ADDRESS . . : 265 KATHLEEN RD  
 CONTRACTOR : BLEDSOE KENNETH R  
 OWNER . . . : QUEZADA JESUS G & LODIE D  
 PARCEL . . . : 03-9589- - -1021- -18-  
 APPL NUMBER: 10-50024577 CP ADD & ALTER RESIDENTIAL  
 DIRECTIONS : T/S: 06/08/2010 01:04 PM RDCONTE ---  
 265 KATHLEEN / HIGHLAND HILLS #39  
 HWY 27 TO DOCS RD TURN LEFT TO MICRO  
 TOWER TURN RIGHT TO KATHLEEN RD TURN  
 LEFT HOUSE IS ON LEFT AT CURVE LOT 39

**STRUCTURE: 000 000 12X24 SCREEN PORCH & DECK**

1. Install diagonal bracing per appendix M by final inspection
2. Double felt is required under shingles
3. Ok to continue

FLOOR FRAMING PLAN
Scale: 1/4" = 1'-0"
6x6 and 4x4 Posts
17'0" DE PRESSURE TREATED

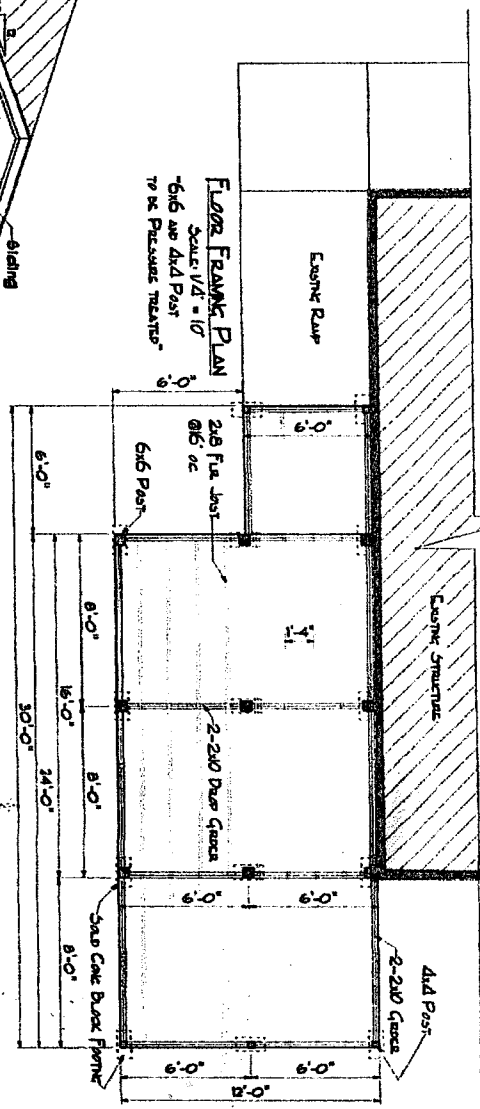
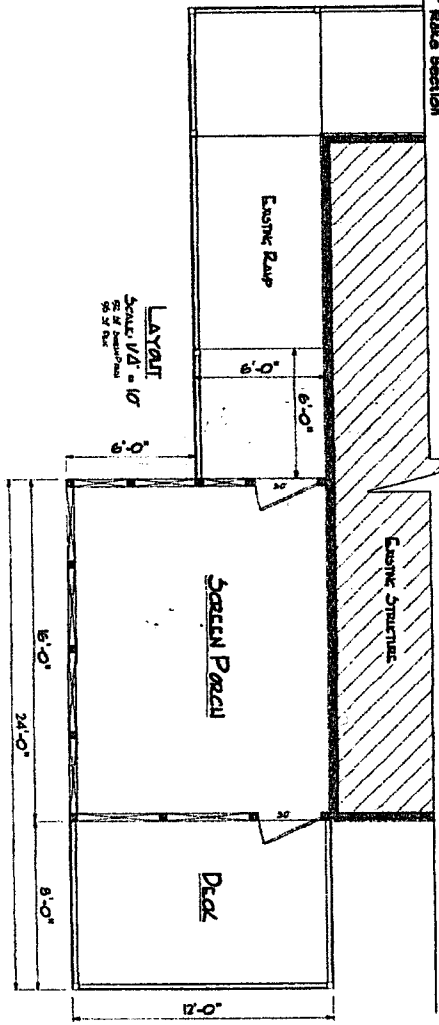
TYP/SQ	REQUESTED COMPLETED	INSP RESULT	DESCRIPTION RESULTS/COMMENTS
R125 01	8/16/10 8/16/10	MR AE	ONE TRADE ROUGH IN VRU #: 001969450 T/S: 08/16/2010 12:17 PM MREARIC brace posts per code double felt under shingles required
R131 01	8/23/10 <u>8-23-10</u>	TI <u>AP-MR</u>	ONE TRADE FINAL VRU #: 001973163 CHECK ROUGH IN ISSUES AT THIS TIME, THEY ARE DONE
